Ribble Valley Borough Council
Housing & Development Control

Planning Application No: 3/2022/0836

Proposal: Proposed rear two storey extension and single storey side extension with balcony over. Conversion of outbuilding to annexe accommodation.

Location: Kay Fold Farm Ramsgreave Drive Blackburn BB1 8NB

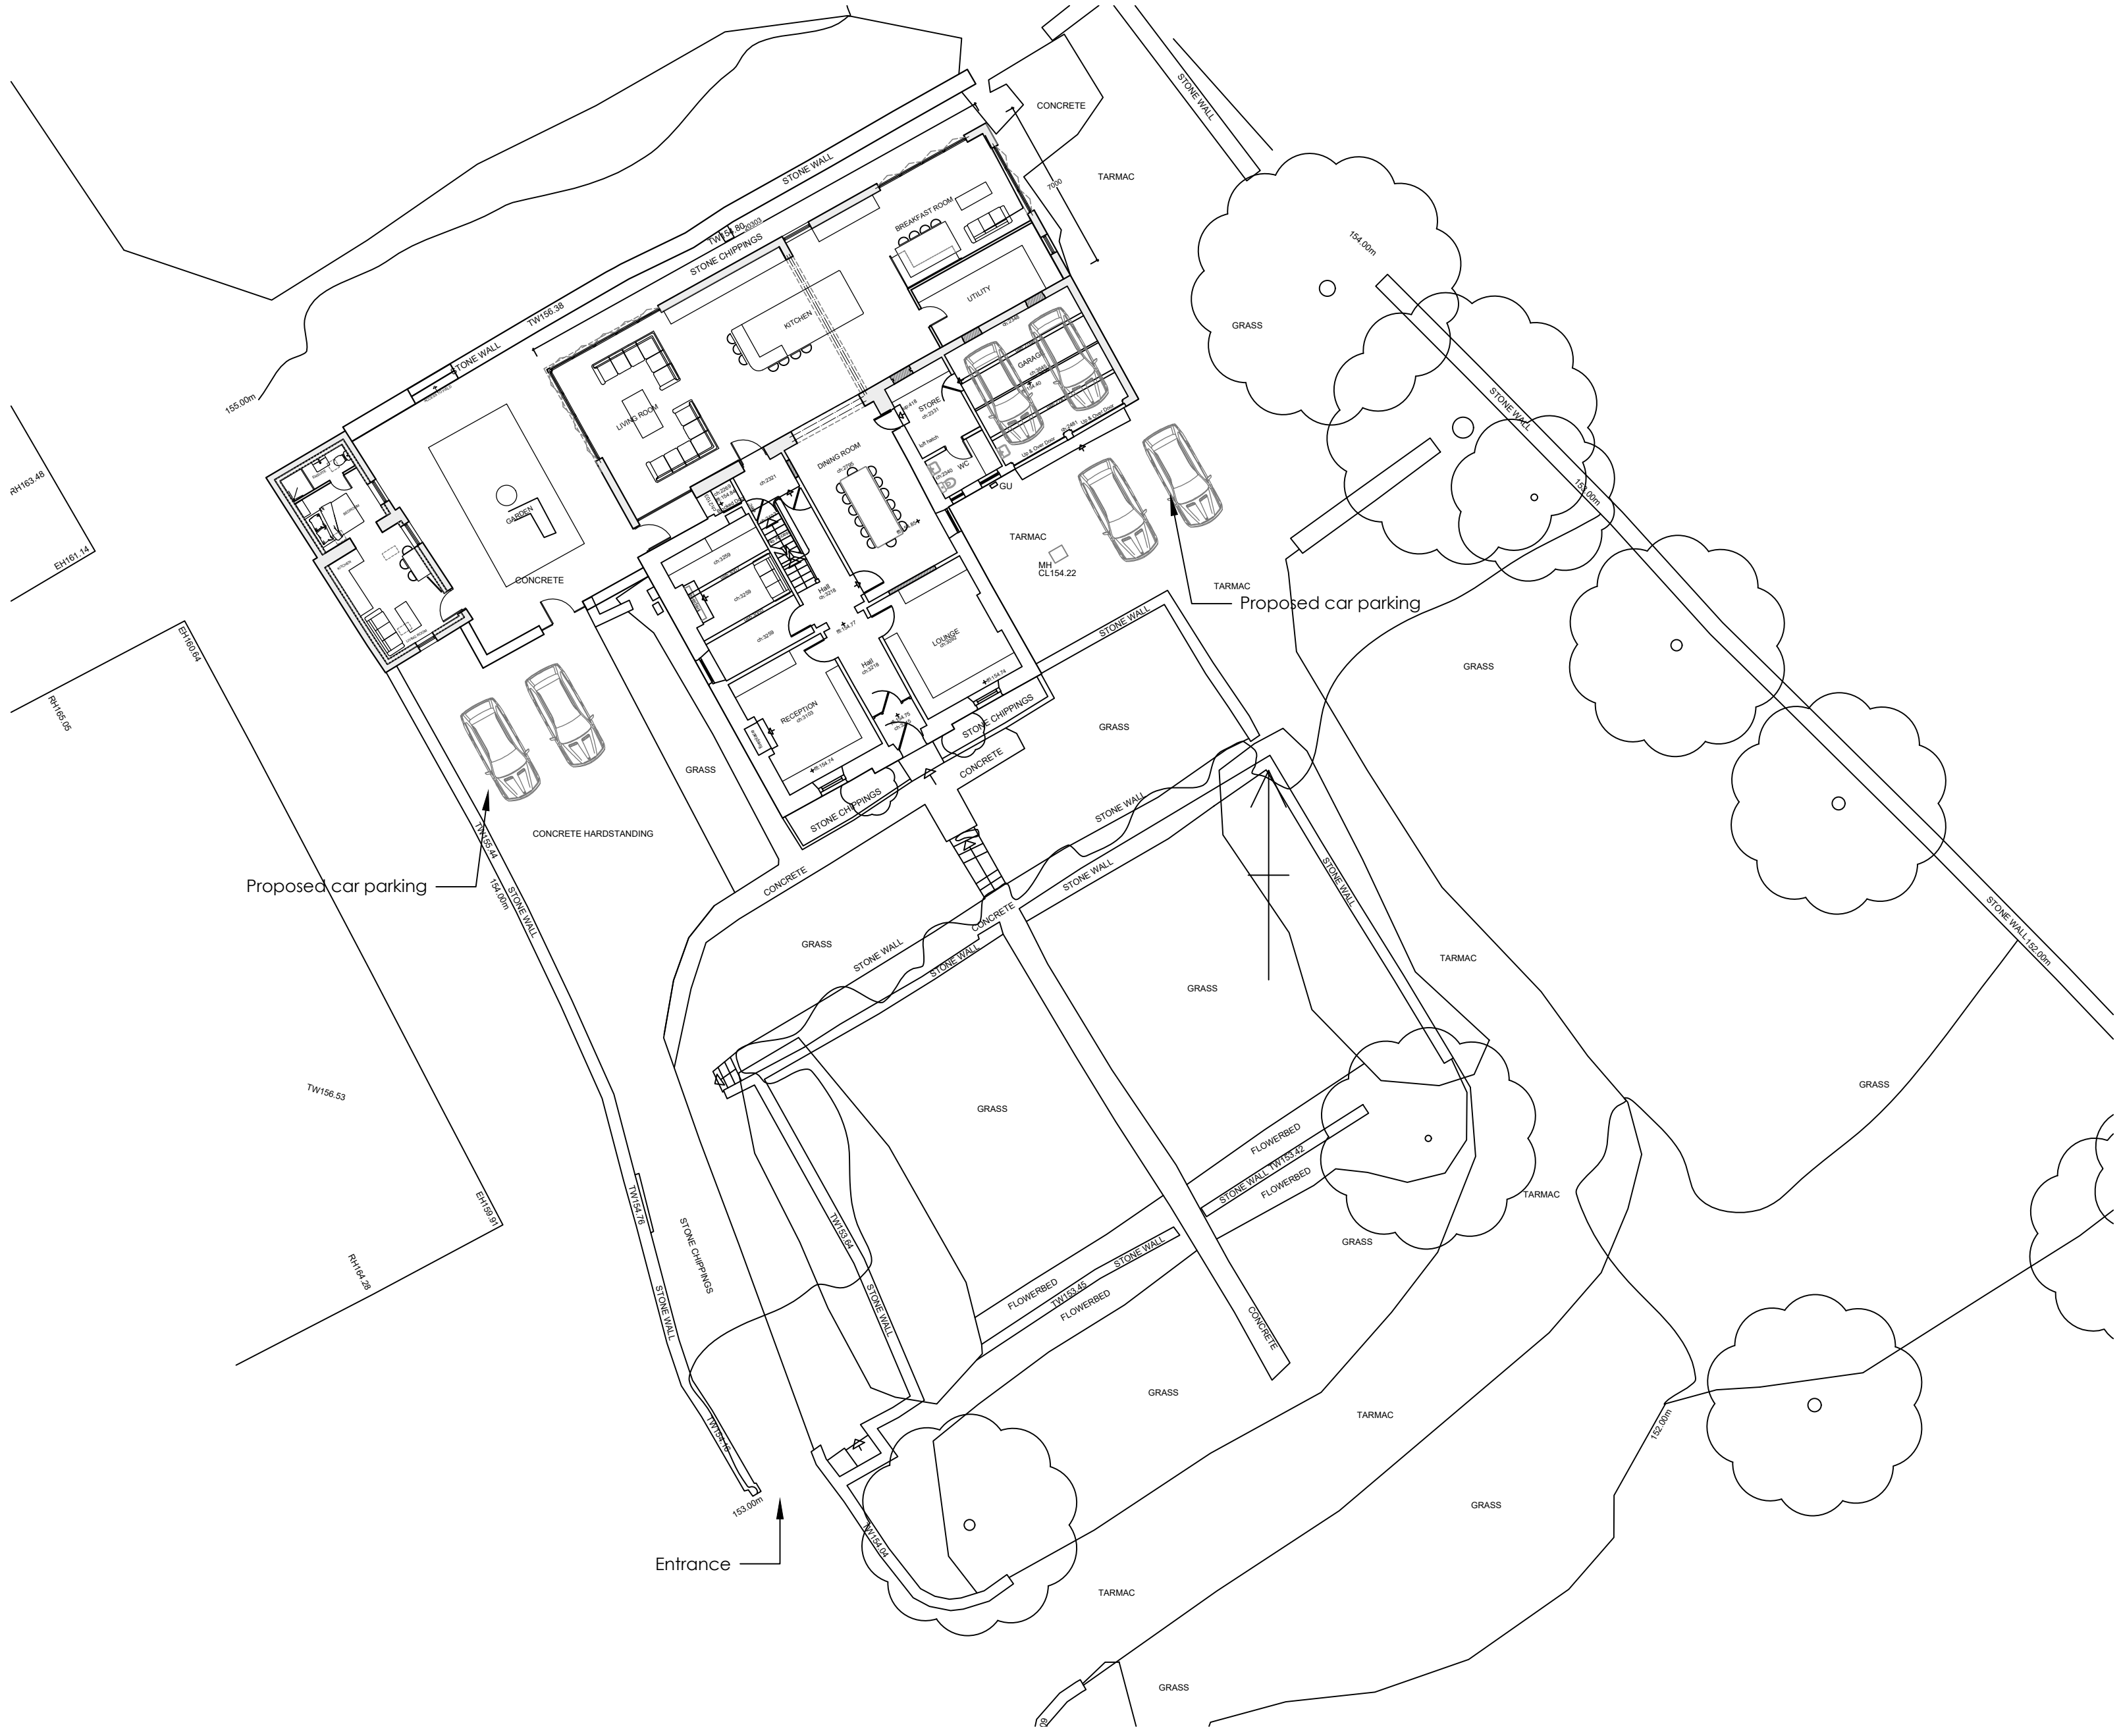
With reference to planning statement: Access and highway safety Ref. 6.16, and Drawing: Proposed site plan 6624-P02, July 22, submitted, there is no objection to this proposal.

- A construction management plan should be produced to highlight how deliveries during construction will be managed and where workers on the site will park 2 during construction. Reason: to minimise the impact of construction on existing residents in the vicinity of the site
